Portishead Branch Line (MetroWest Phase 1)

Planning Inspectorate Reference: TR040011

9.3.1 ExA.SoCG-NSC.D7.V2 – Statement of Common Ground

Date: April 2021

2.38 - Portishead Station Car Park Layout, Landscaping and New Boulevard and Access Plan

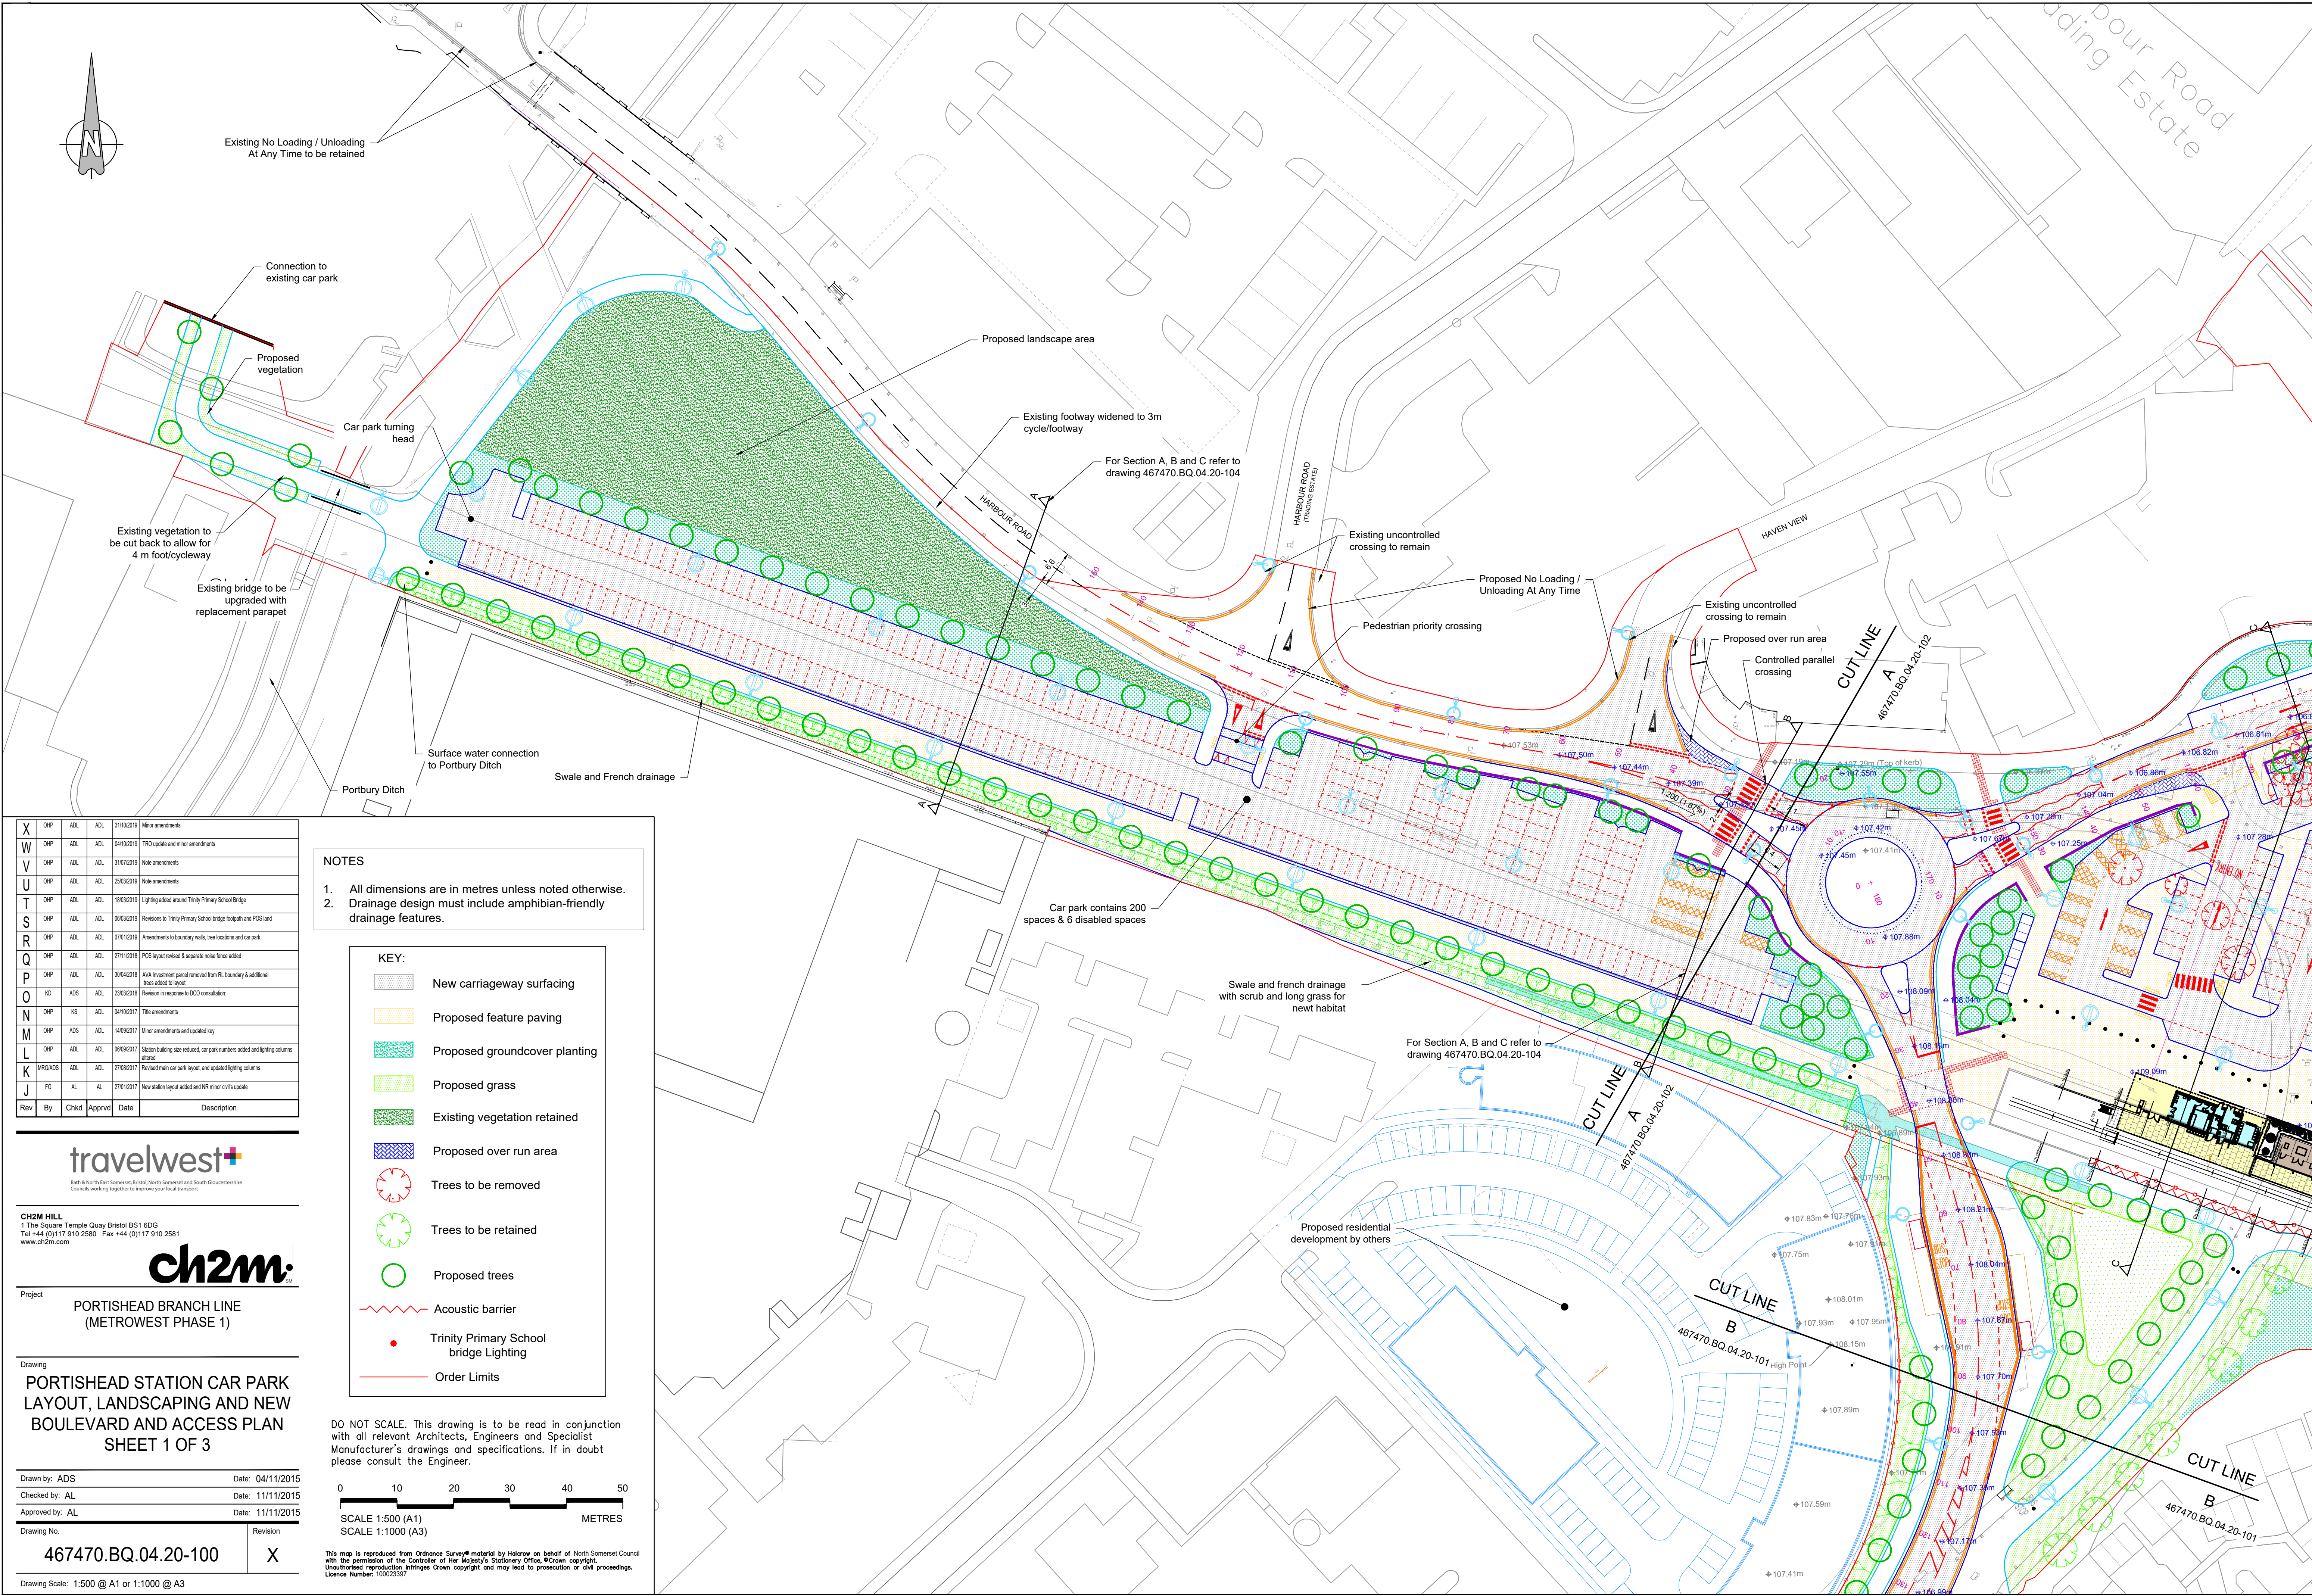
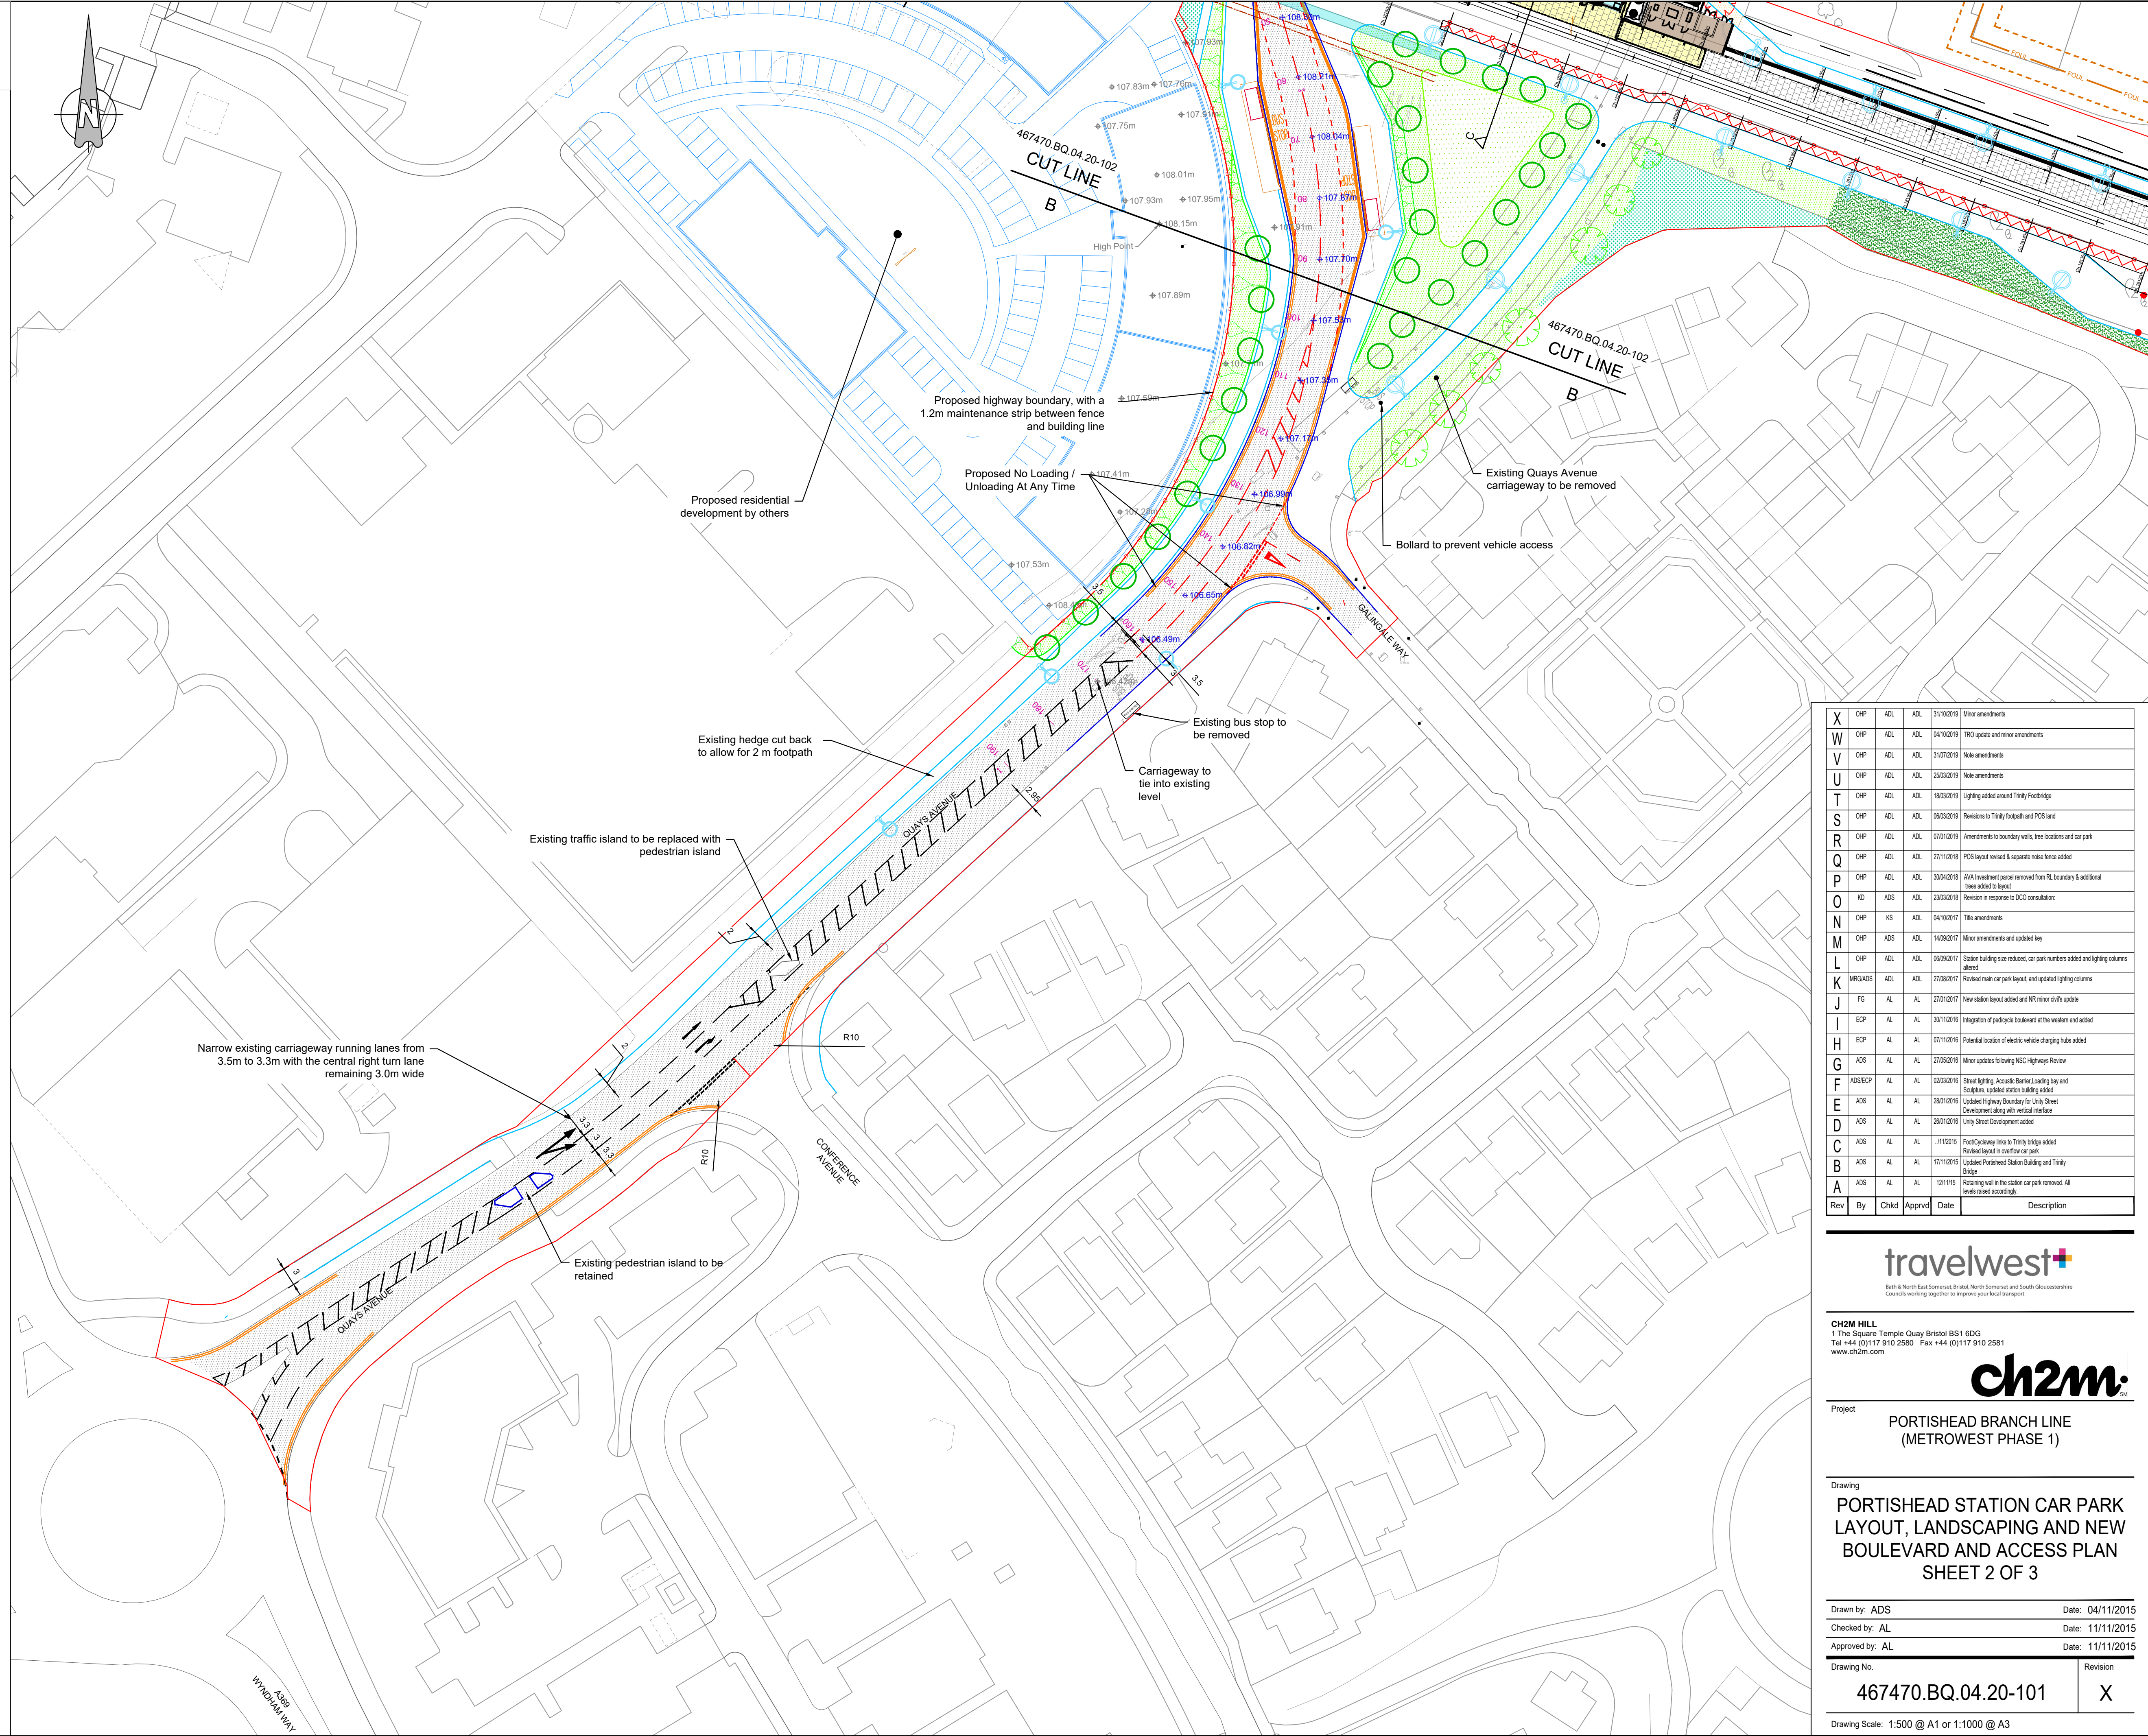
- (a) Requested 14 days' notice before the end of the 8 week approval period prior to deemed consent of Requirements (as set out in Schedule 2 of the dDCO taking effect;
- (b) Requested further detail on how the larger car park access at the junction with Harbour Road and Papermill Gardens will operate. The proposed operation of

this junction will be tested to demonstrate that it will operate satisfactorily at the detailed design stage;
